# KITTITAS COUNTY

## DEPARTMENT OF PUBLIC WORKS

**TO:** All Staff  
**FROM:** Public Works Plan Review Team  
**DATE:** April 5<sup>th</sup>, 2024  
**SUBJECT:** CU-24-00001 Vantage Valley Properties

CROSS VALLEY
 NATIONAL TRAINING
 CENTER
 SITE PLAN
 OCTOBER 9, 2023

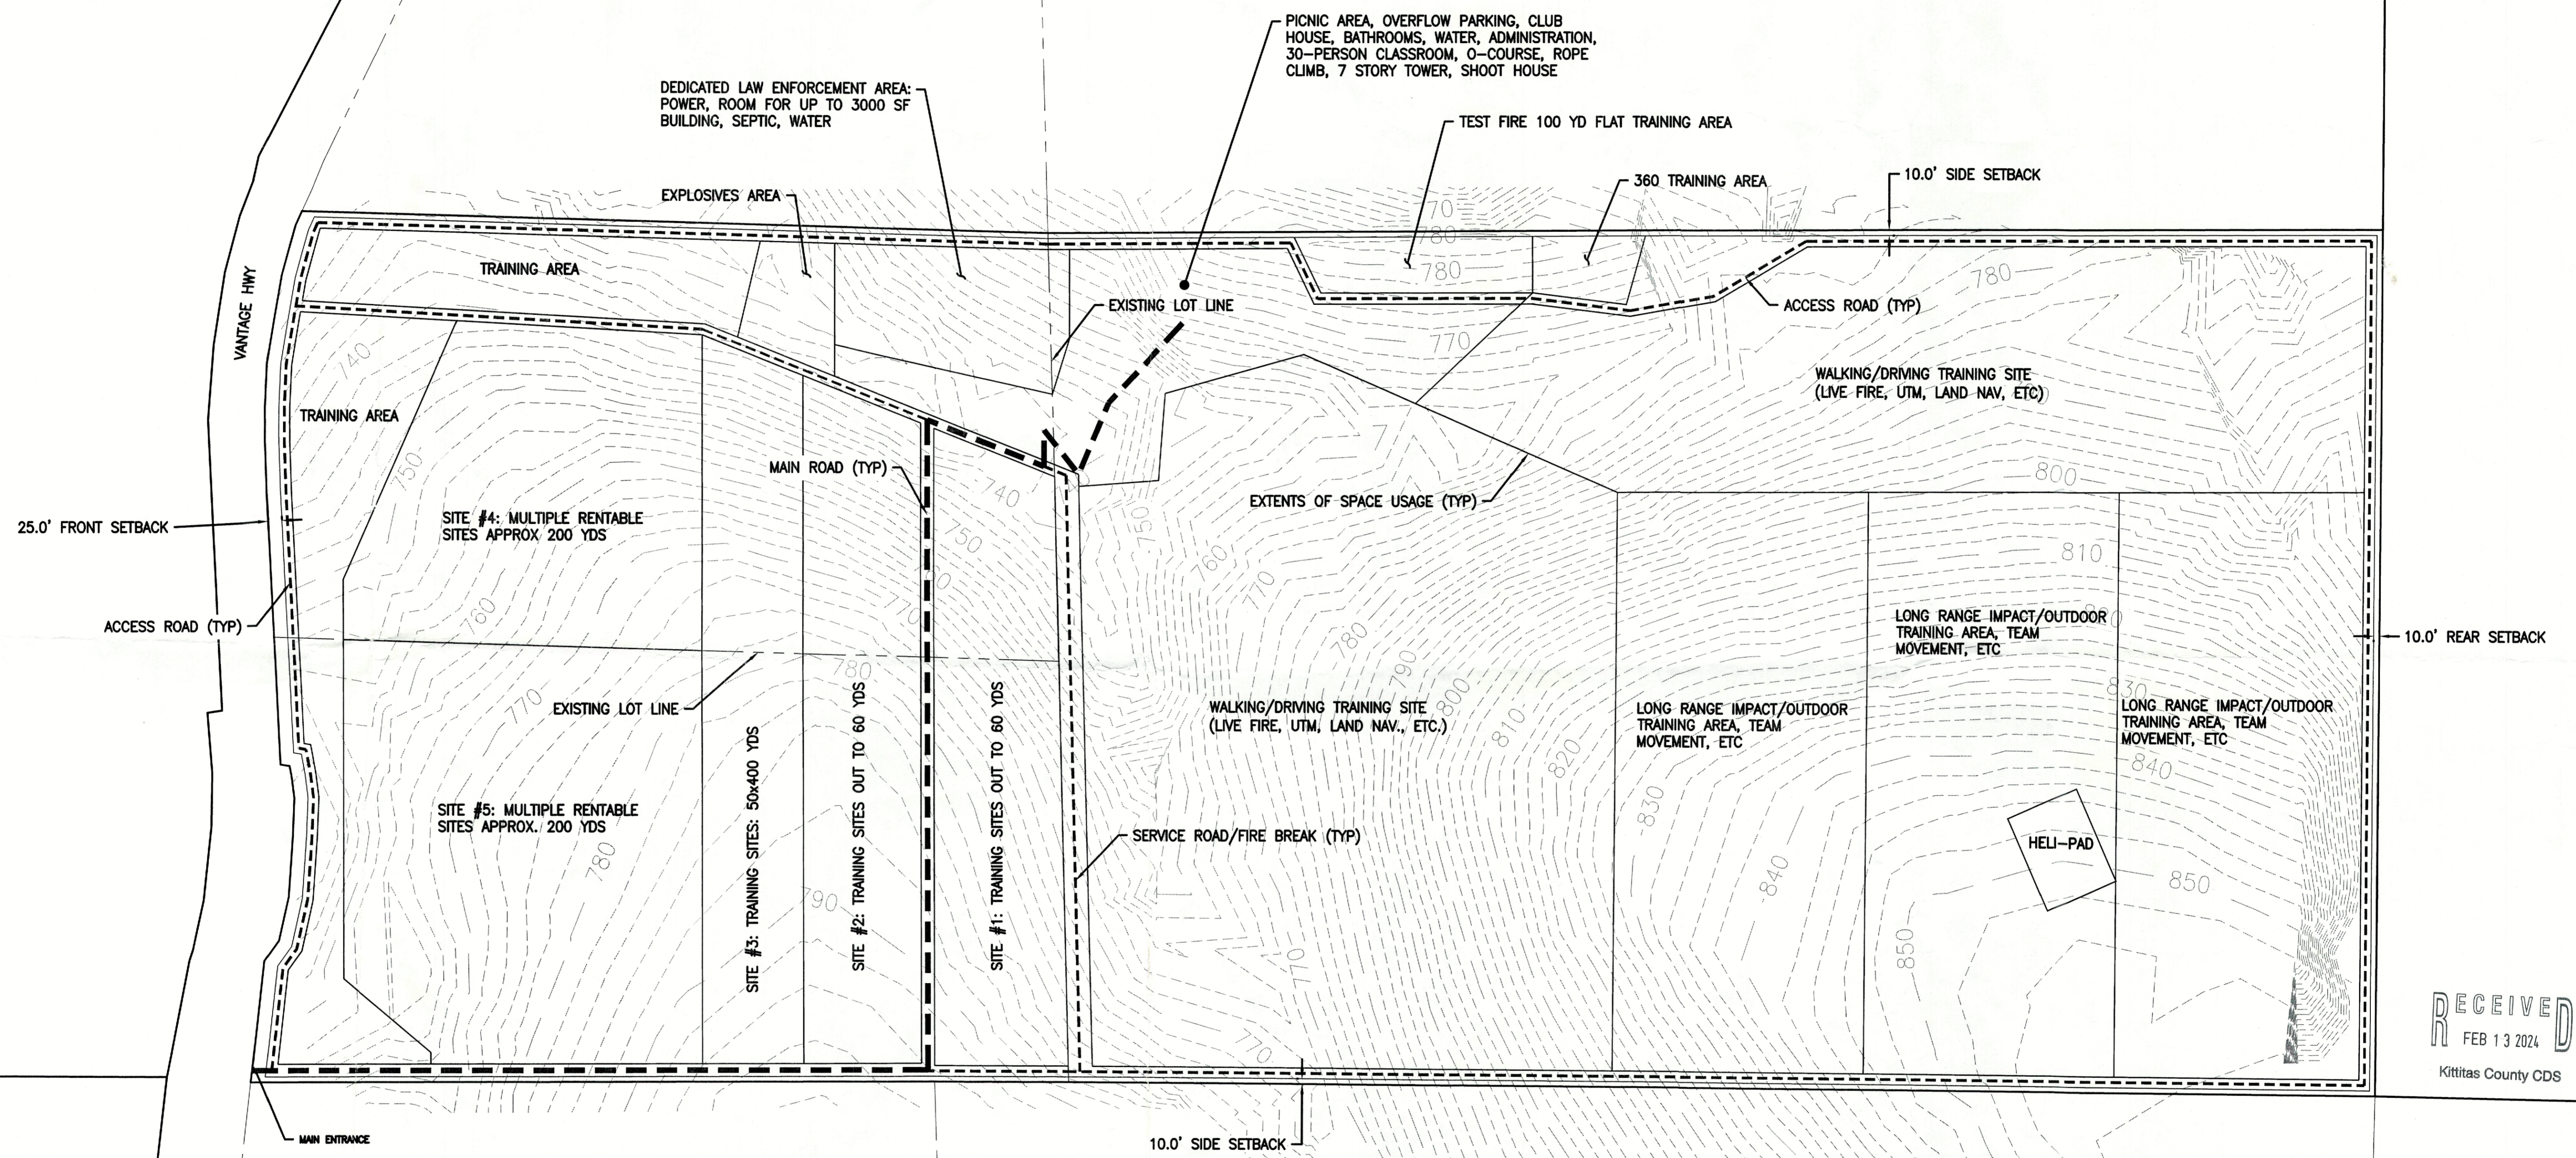
<b>ACCESS</b>	<ol style="list-style-type: none"> <li>1. Access is not permissible at the location on the site plan provided.</li> <li>2. An engineered access plan may be required.</li> <li>3. Provide Public Works with a plan for the guardrail that meets WSDOT requirements from a licensed civil engineer.</li> <li>4. An approved access permit for commercial access shall be required from the Kittitas County Department of Public Works prior to creating any new driveway access or altering an existing access.</li> <li>5. Driveways and Roads greater than 150' in length are required to provide a fire apparatus turnaround that is in compliance with Appendix D of the International Fire Code.</li> <li>6. Per Kittitas County Code, only one access is permitted. A Road Variance application will need to be applied for if 2 accesses are built. Road Variance does not guarantee second access.</li> <li>7. In addition to the above-mentioned conditions, all applicable Kittitas County Road Standards apply.</li> </ol>
